From: Amanda Scholes on behalf of Planning.Responses
Sent: 17 May 2017 09:16
To: Planning Scanning
Subject: FW: LU/127/17/DOC - Discharge of drainage conditions

From: Paul Cann
Sent: 16 May 2017 14:17
To: Anita Gardner
Subject: RE: LU/127/17/DOC - Discharge of drainage conditions

Paul,
The above details have been submitted to accord with condition 4 of planning permission LU/173/16/PL. Can you advise if the submitted information is satisfactory in compliance with the condition?
Thanks
Anita

EXPLORATORY HOLE LOCATION PLAN

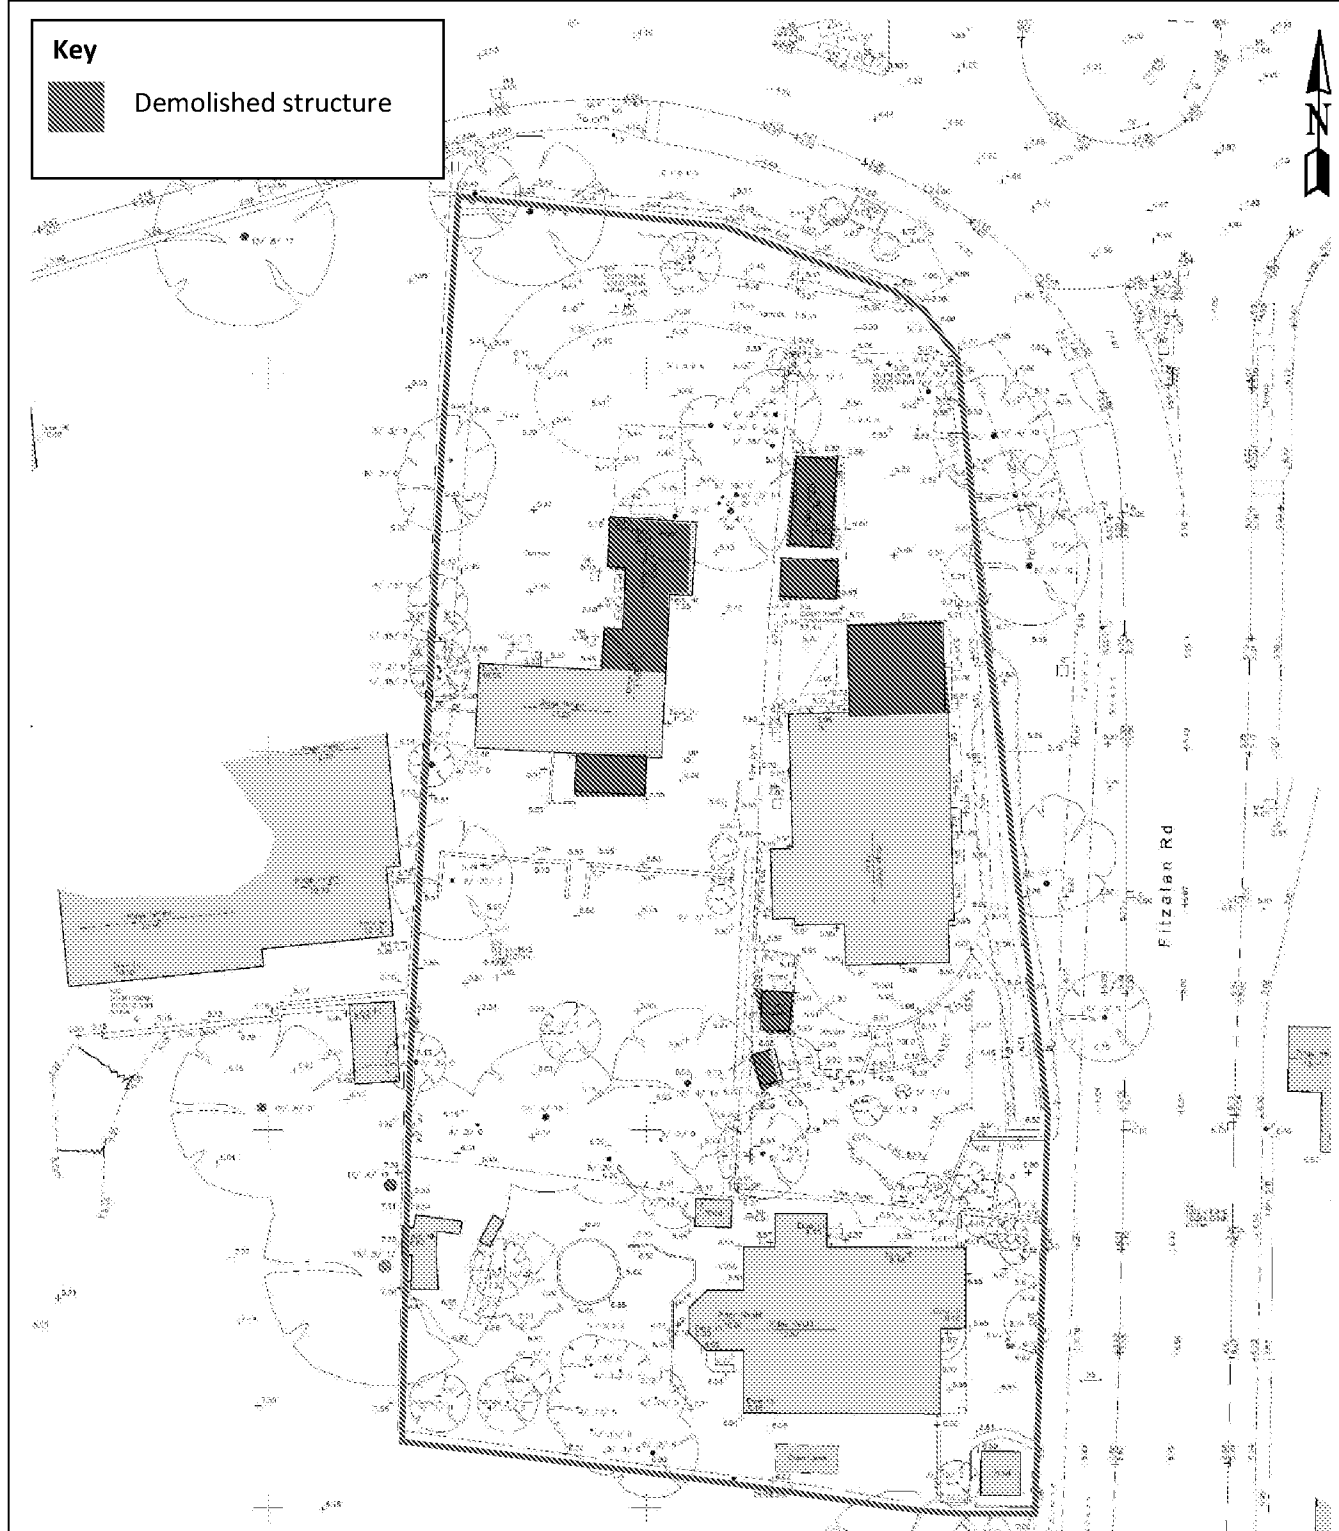
From reading their geotechnical report, it appears that they have undertaken two percolation tests, one in TP1 and one TP2. It is noted that these have not been undertaken in the winter period and have only had one test done in each trial hole (as opposed to three in each). The results in TP1 are ok, whilst those in TP2 are not. The better result was achieved in the trial hole that penetrated the chalk layer (as you would expect).

At this stage, and with the information provided, it is not possible to dismiss the use of soakaways, and therefore I would suggest that more investigations are carried out with the excavation of further trial holes (at the location of potential soakaways and sufficiently penetrating the chalk layer), and further percolation tests undertaken, in the winter period.

Since winter is a long way off, they may wish to undertake these works now so we can get more idea of what test results to expect, bearing in mind they are likely to be worst in the winter. Although, this should not be treated as a replacement for winter testing. If they proceed with this idea, then they are advised to discuss this further with us, in order to agree the proposed trial hole locations/depths.
